Design Review

Site: 2 – 4 Waterloo Square, Bognor Regis (Rev. B)
Status: Full Planning Application
Reference: BR/282/19/PL
By: D. Edwards
Date: 29th April, 2020

4-4. Proposed Rear Section / Elevation

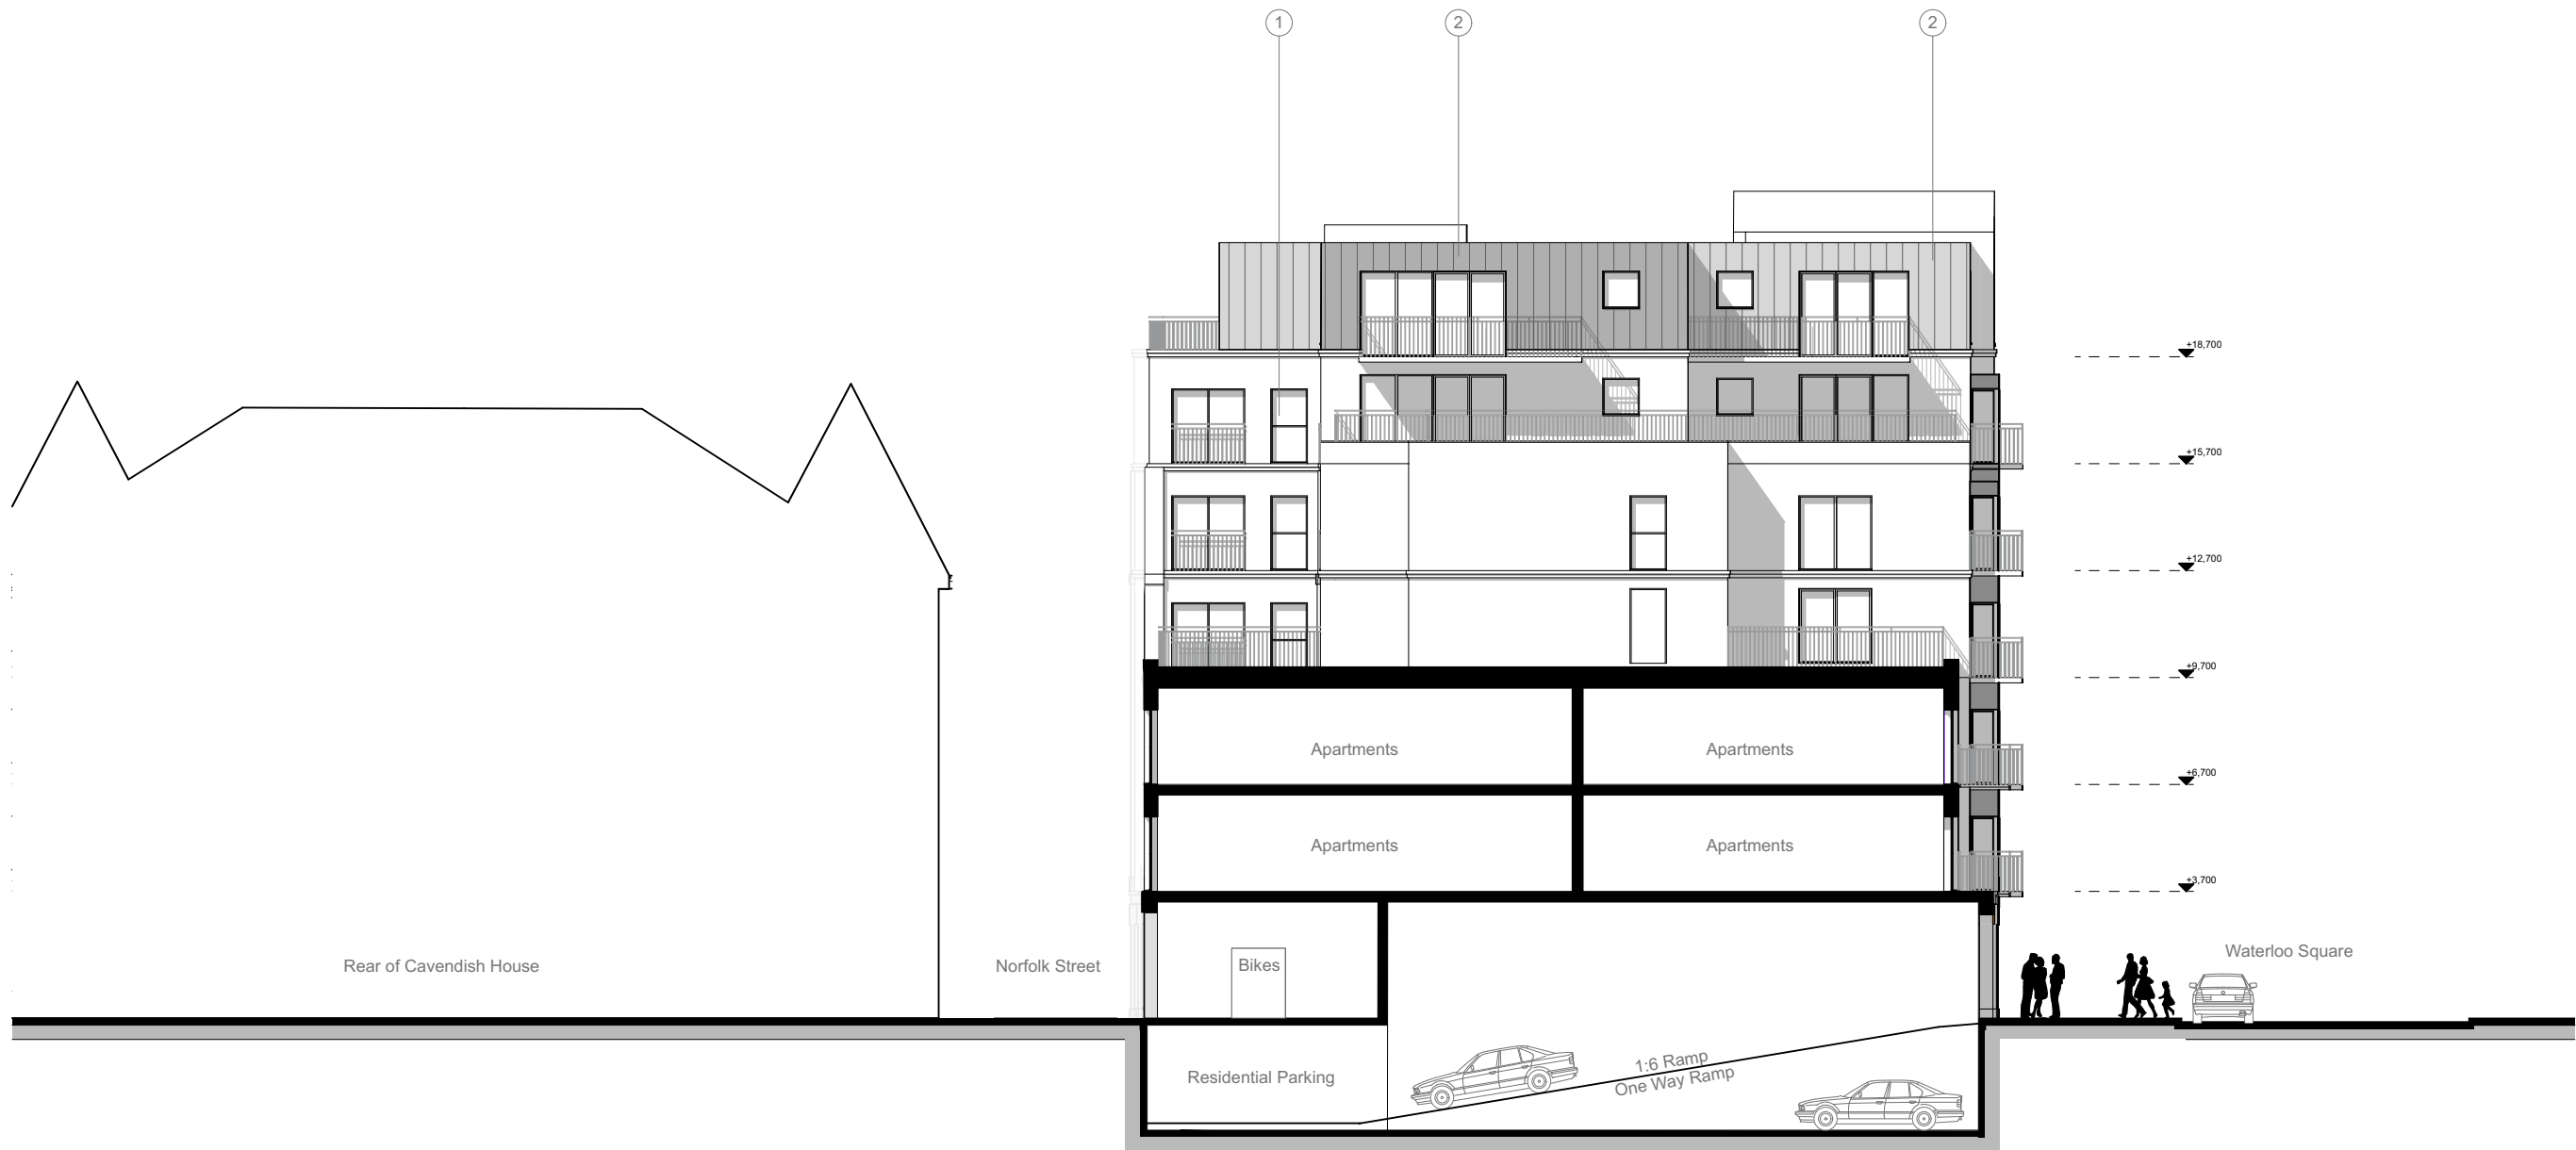
- b) Six proposed floors alongside four existing at The Esplanade.
- 8) This is particularly significant when the proposed scheme is considered in relation to the wider Waterloo Square street frontage and apparent from the proposed rear elevation.
